Appeal Decision

Appeal Ref: APP/R5510/W/21/3278247
25 Friar Road, Hayes UB4 9BZ

- The appeal is made under section 78 of the Town and Country Planning Act 1990 against a refusal to grant planning permission.
 - The appeal is made by Mr Manjit Singh Jhand against the decision of the London Borough of Hillingdon.
 - The application Ref: 21981/APP/2021/249, dated 20 January 2021, was refused by notice dated 24 March 2021.
 - The development proposed is Erection of two storey, three-bed, attached dwelling with associated parking and amenity space involving single storey rear extension to existing house.
-

NOTES :		
	Date	Revisions
Client MR. MANJIT SINGH JHAND		
Job Title 25 FRIAR ROAD HAYES UB4 9BZ		
Drawing Title PROPOSED ELEVATIONS		
Scale: 1 : 100 (A3)		
Date: JANUARY 2021		
Checked by:	Drawn by: RS	
Drg No. TP/465/06		Rev.

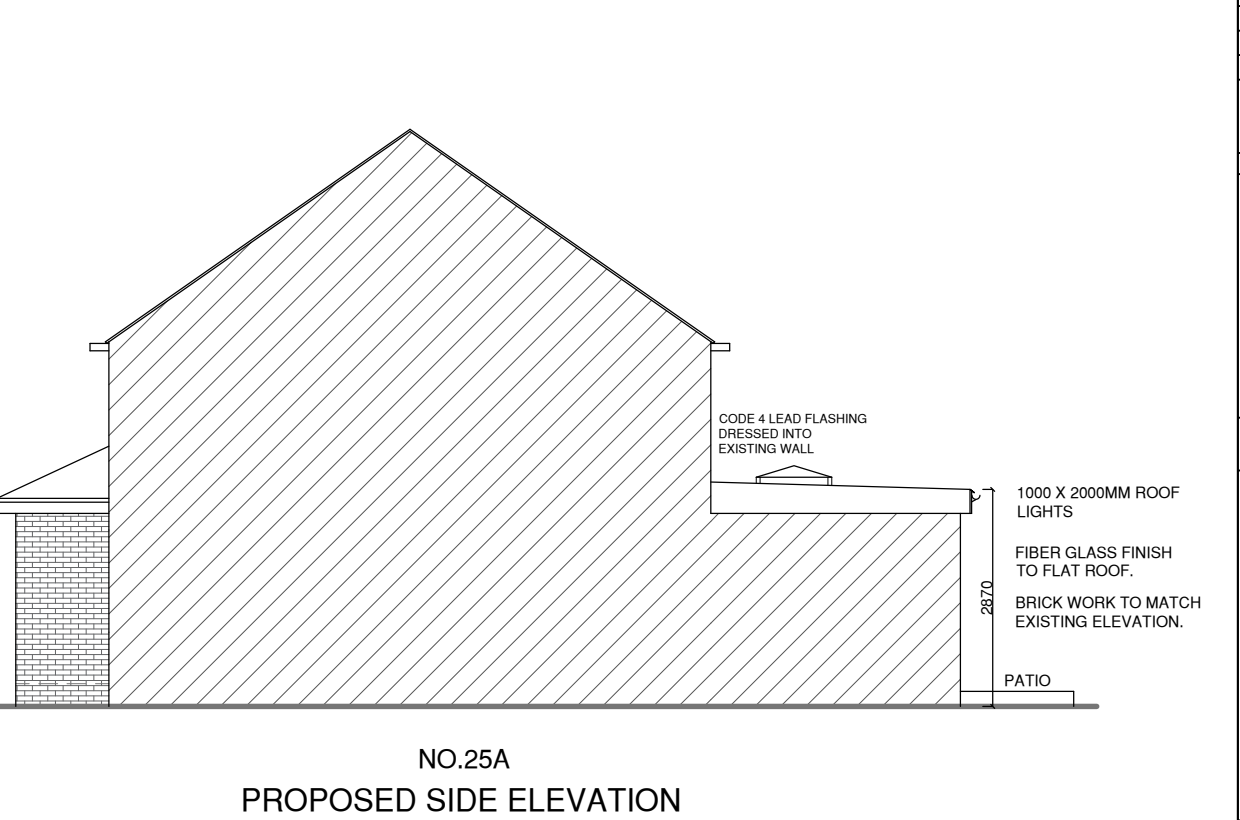
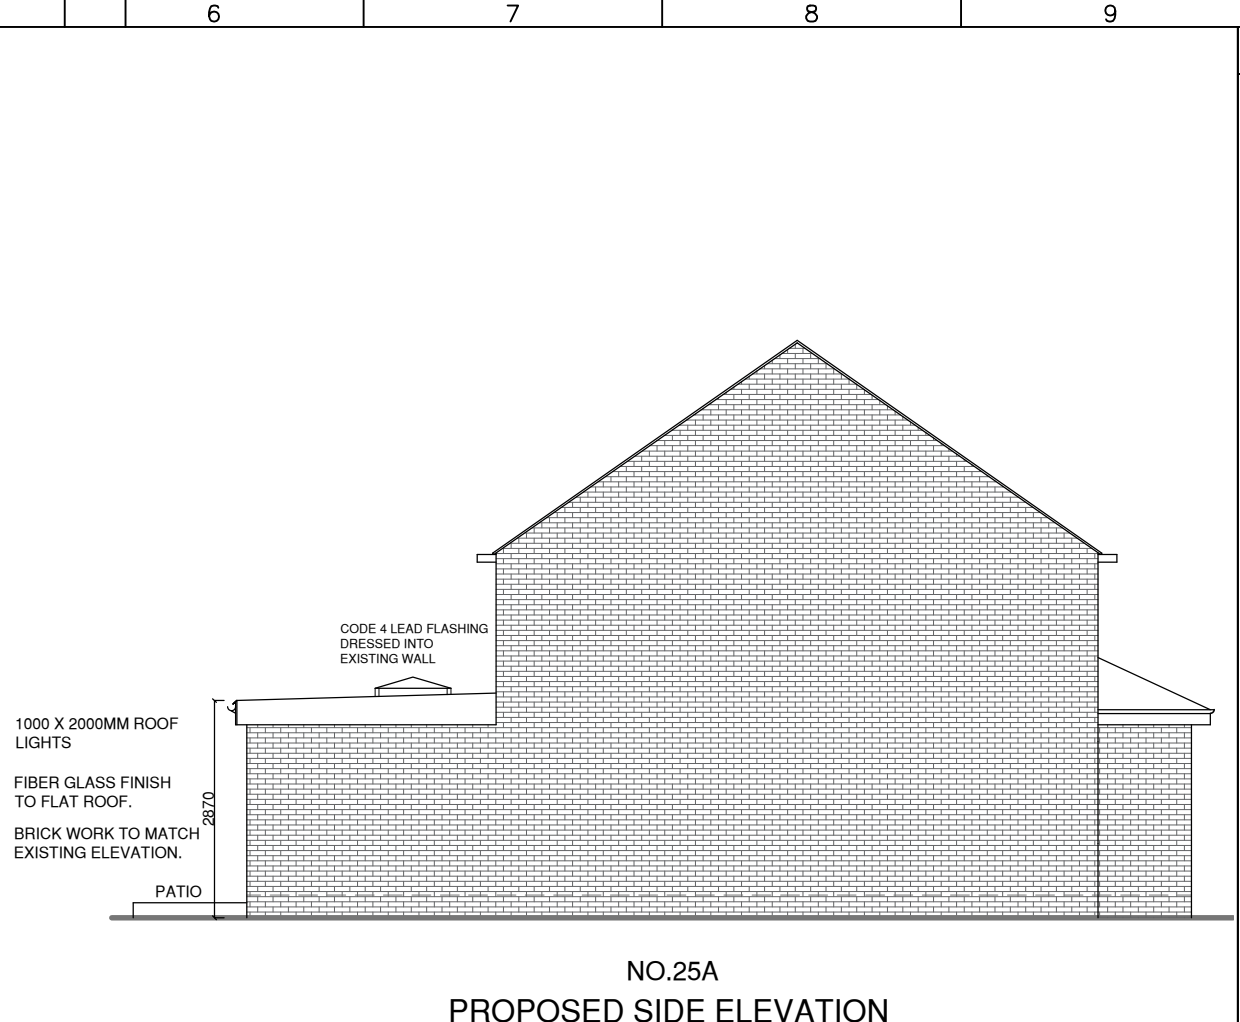
8. The proposed dwelling has been specifically designed to mirror that of the host dwelling. Whilst rows of three houses are not uncommon within the street scene, these are located in a different arrangement to the proposal. In this position, an additional dwelling attached to the appeal dwelling, to create a row of three houses, would detrimentally undermine the symmetry of the opposite pair of semi-detached houses that denote the access into Marian Close. It would appear as a visually prominent and discordant feature within the locality. As a dwelling as proposed, it would not make efficient use of the land.

Drawing Title
BLOCK PLAN

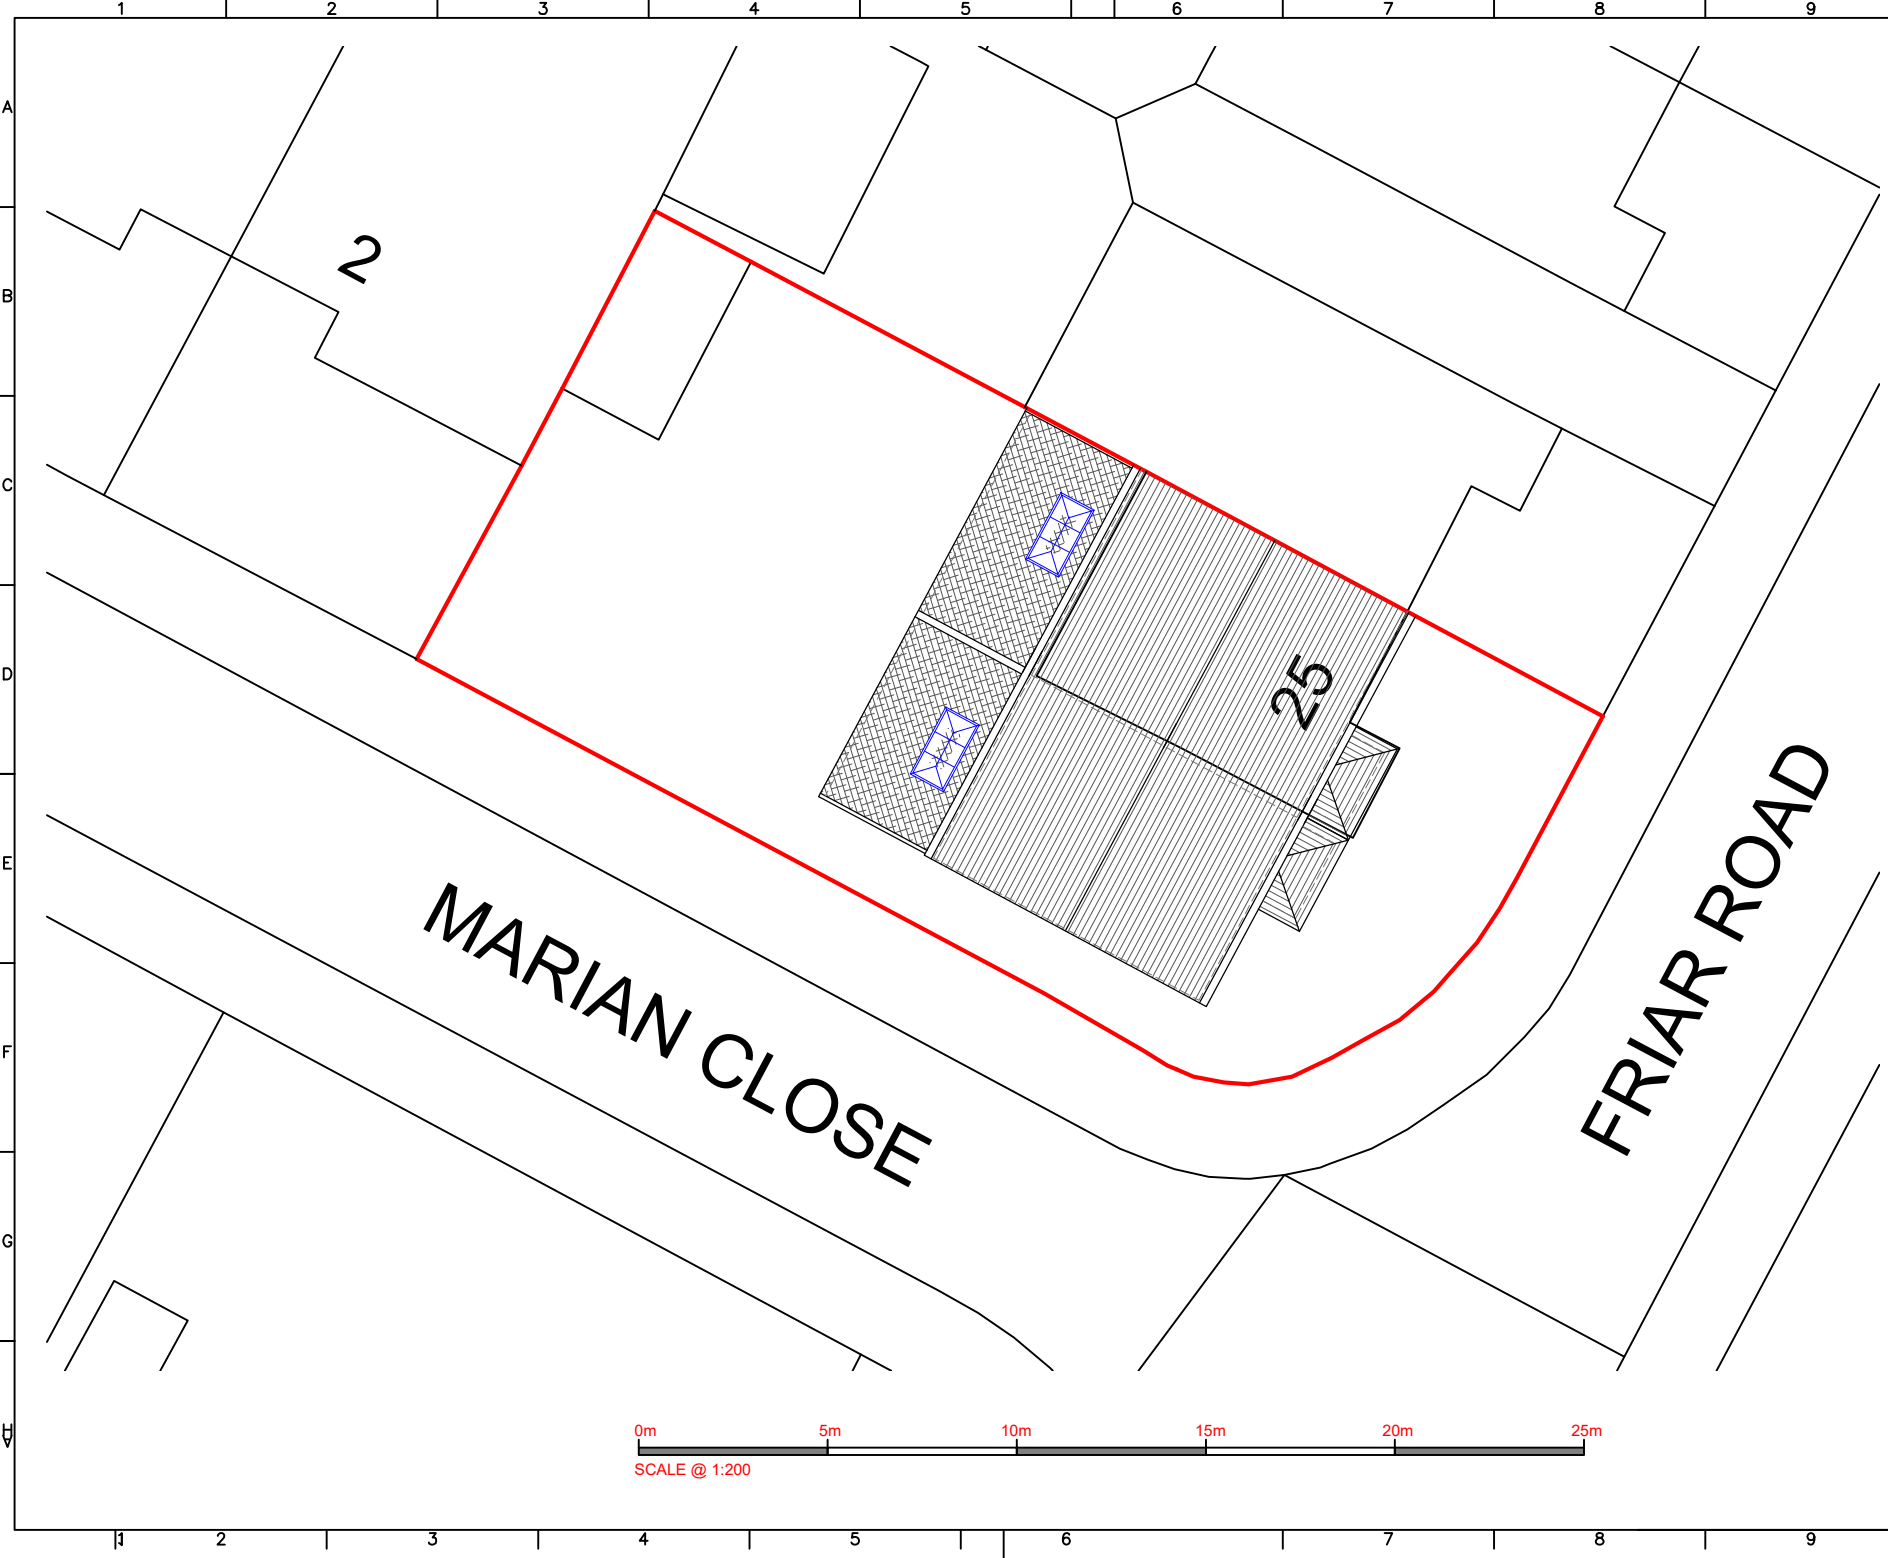
7. A new dwelling as proposed would encompass most of the side garden area and detrimentally erode the sense of spaciousness that the existing side garden creates. In a built-up area, it provides spatial relief and openness upon transitioning from one residential road into another.

9. In addition, a new dwelling in this location would project forward of the return building line of No. 2 Marian Close that is located behind the appeal site. Given the close relationship between the two, the proposal would represent an uncharacteristic build pattern to the area. It would appear as a conspicuous and obtrusive form of development seen in the approach from Marian Close towards Friar Road and thus result in harm arising to the character and appearance of the area.
